# KITTITAS COUNTY FIRE MARSHAL'S OFFICE

Re: Cameron (BL-11-00007)

After conducting a review of the above named project, I have the following comments:

BOUNDARY LINE ADJUSTMENT PREPARED FOR DUANE CAMERON A PORTION OF THE WEST 1/2 OF SECTION 25, TOWNSHIP 20N., RANGE 16E., W.M. KITTITAS COUNTY WASHINGTON		
DWN BY G. WEISER	DATE 02/2011	JOB NO. 11009
CHKD BY D. NELSON	SCALE 1"=200'	SHEET 1 OF 1

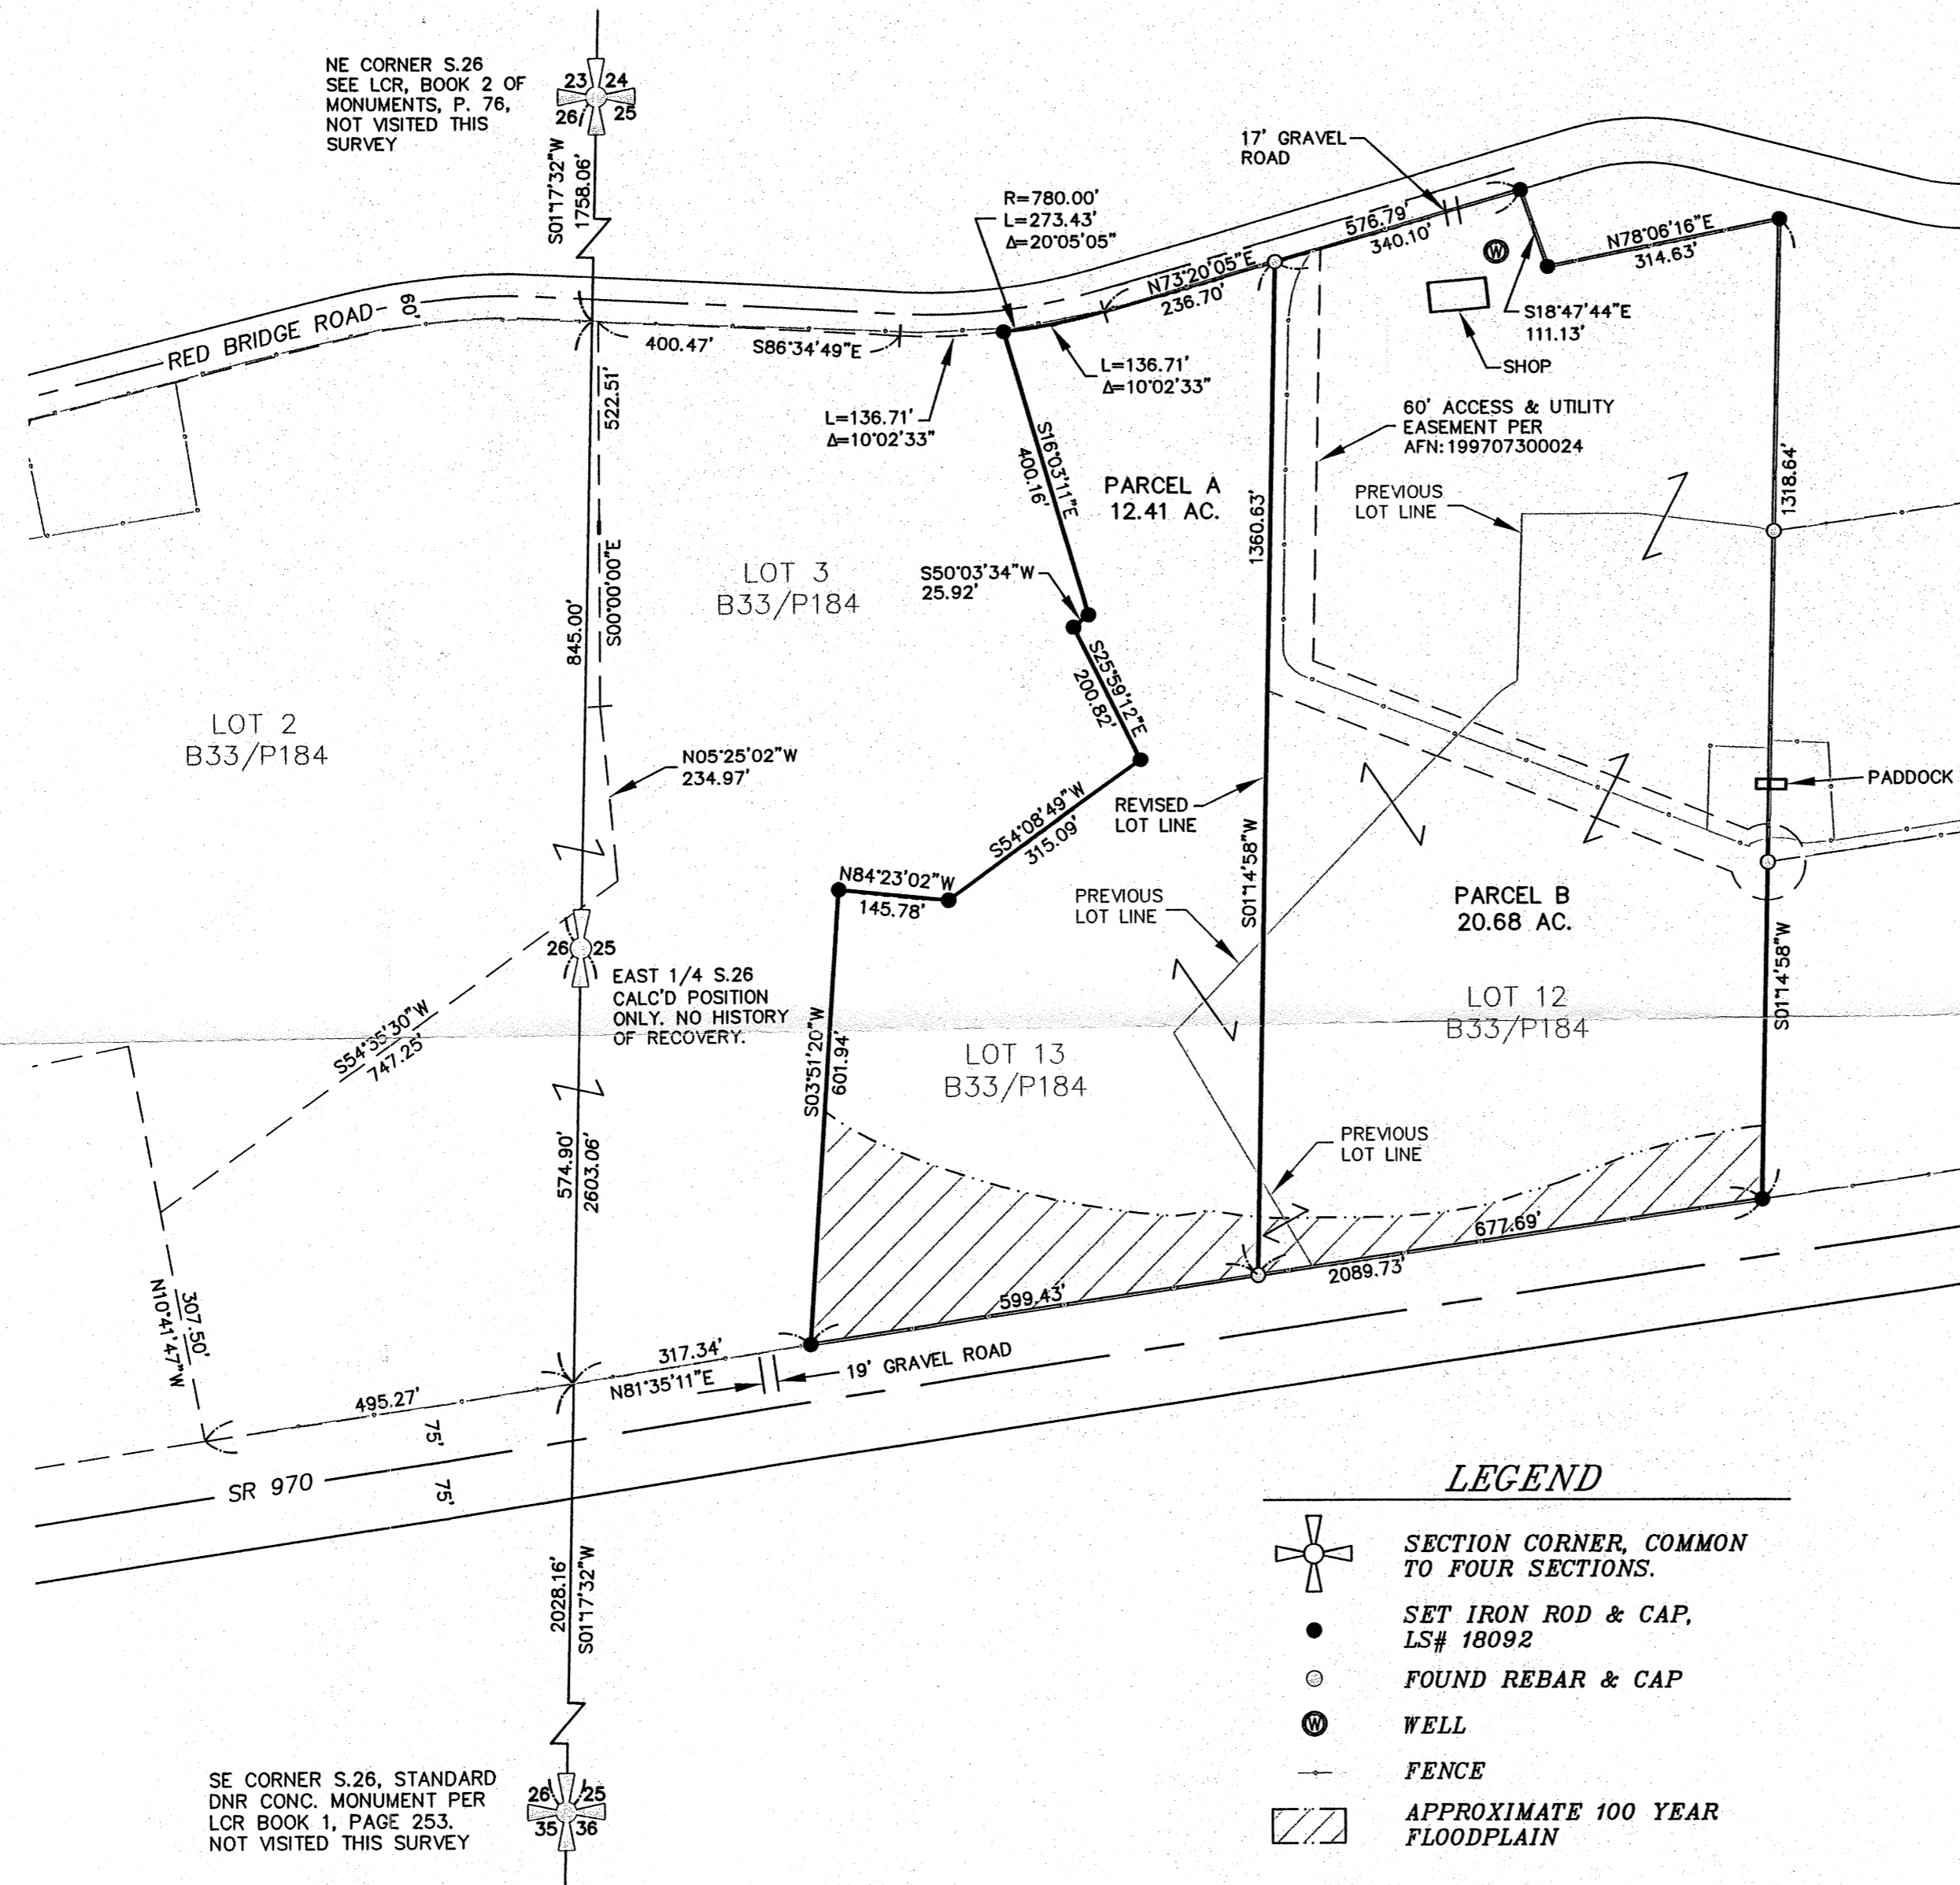
- Ensure that boundary line adjustments do not infringe upon existing structures, to include propane tanks, barns, shops, residences, etc.
- Creation of any additional roads or access must comply with the International Fire Code.
- All future development must comply with the International Fire Code.
